**Preliminary Acceptance Punchlist**  
**El Paso County – Department of Public Works - Stormwater Section**

Project Name:	Rolling Hills Ranch Filing 3
EDARP Filing Number(s):	SF2116
ESQCP Number:	ESQ2329
Attendees:	DPW SW: Dylan Finley DPW Development Services: Brad Walters, David Parkerson, Spencer Pirzadeh, Gilbert LaForce Developer: Lawrence Grahem
Date of Walk-Thru:	08/02/2023
Walk-Thru Number:	1

ROLLING HILLS RANCH FILING 3  
AT MERIDIAN RANCH  
STREET AND UTILITY PLANS  
COASTAL HILLS LN. + STORM #1

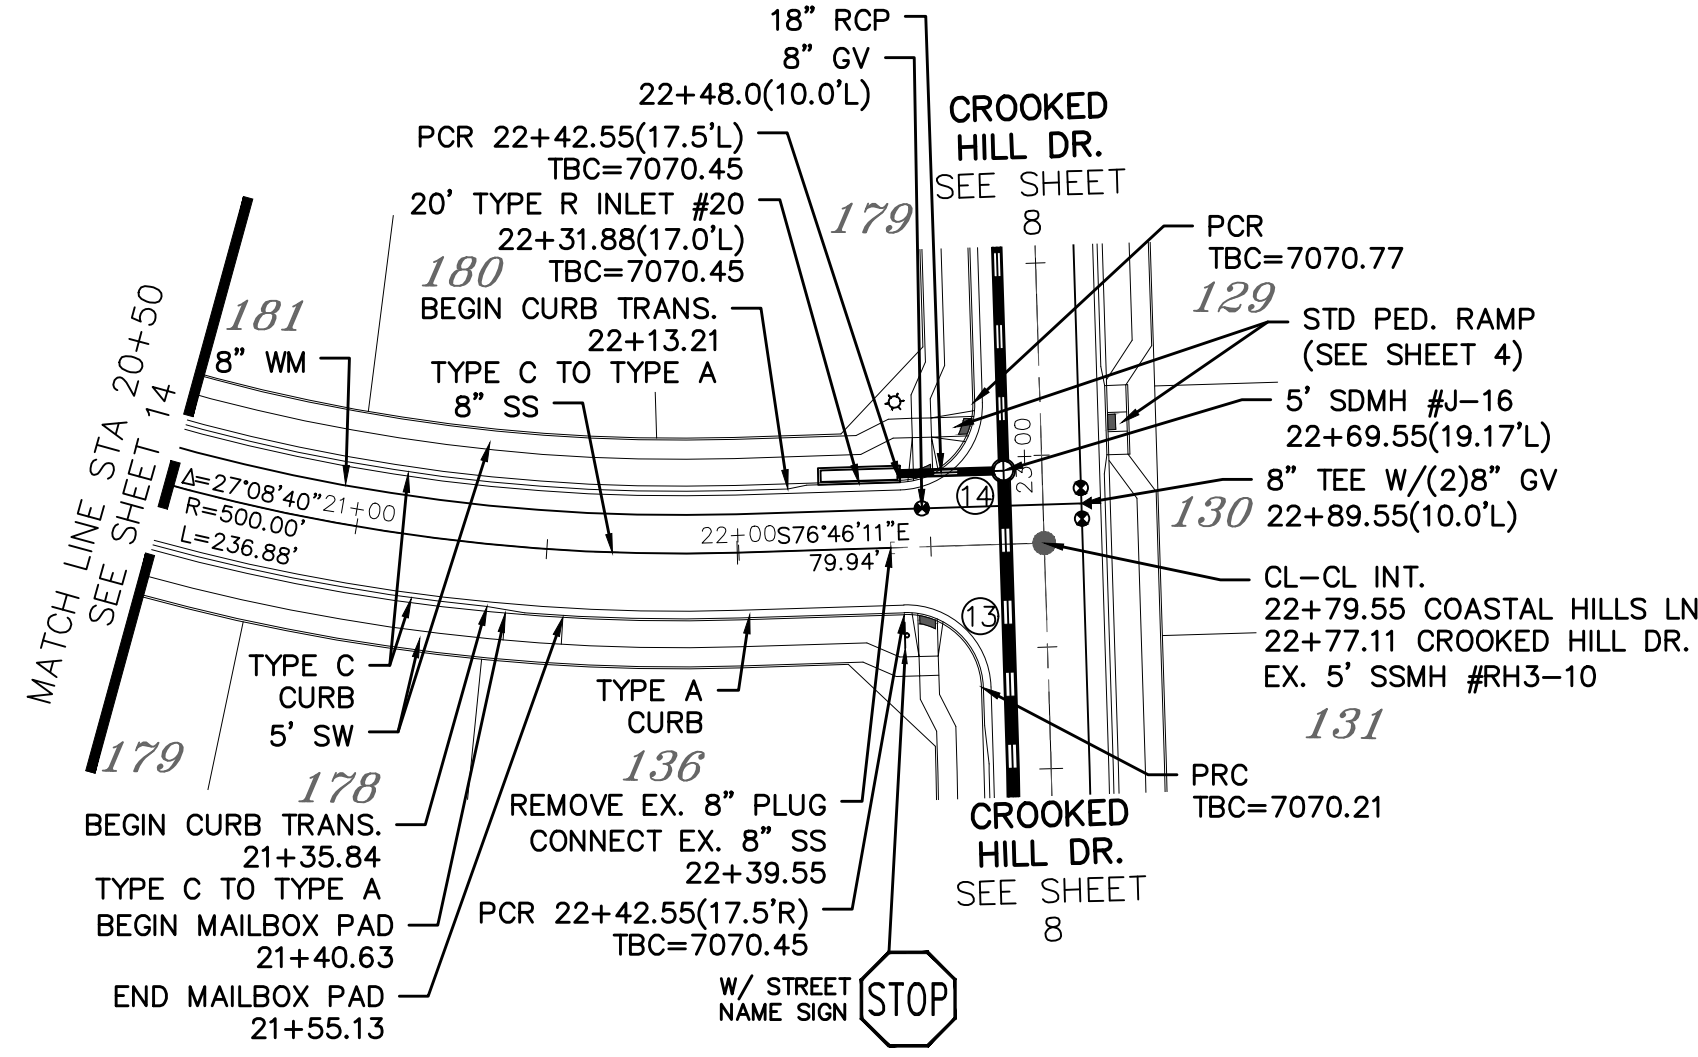
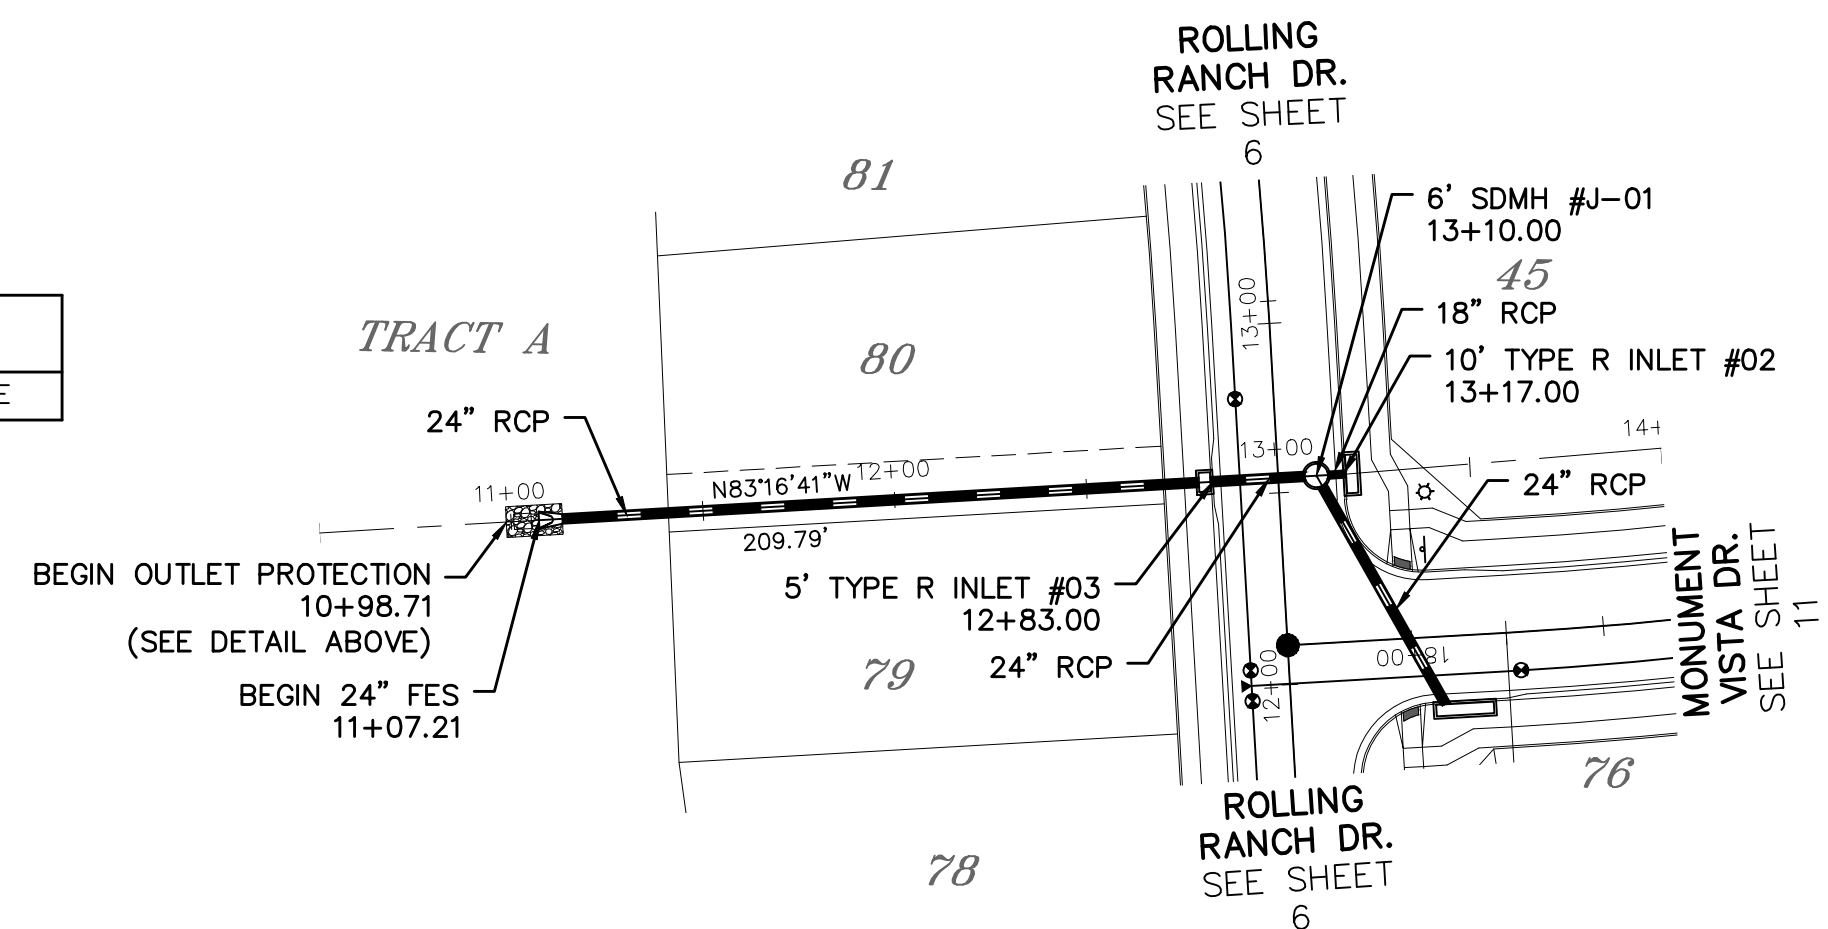
**Culverts [Construction Drawings Sheet 15]:**

- Storm #1, install outlet protection per plans. Riprap overburdened with sediment. (Photo 5)

Photo 5: Storm #1, install outlet protection per plans. Riprap overburdened with sediment. Remove sediment and reestablish outlet protection.
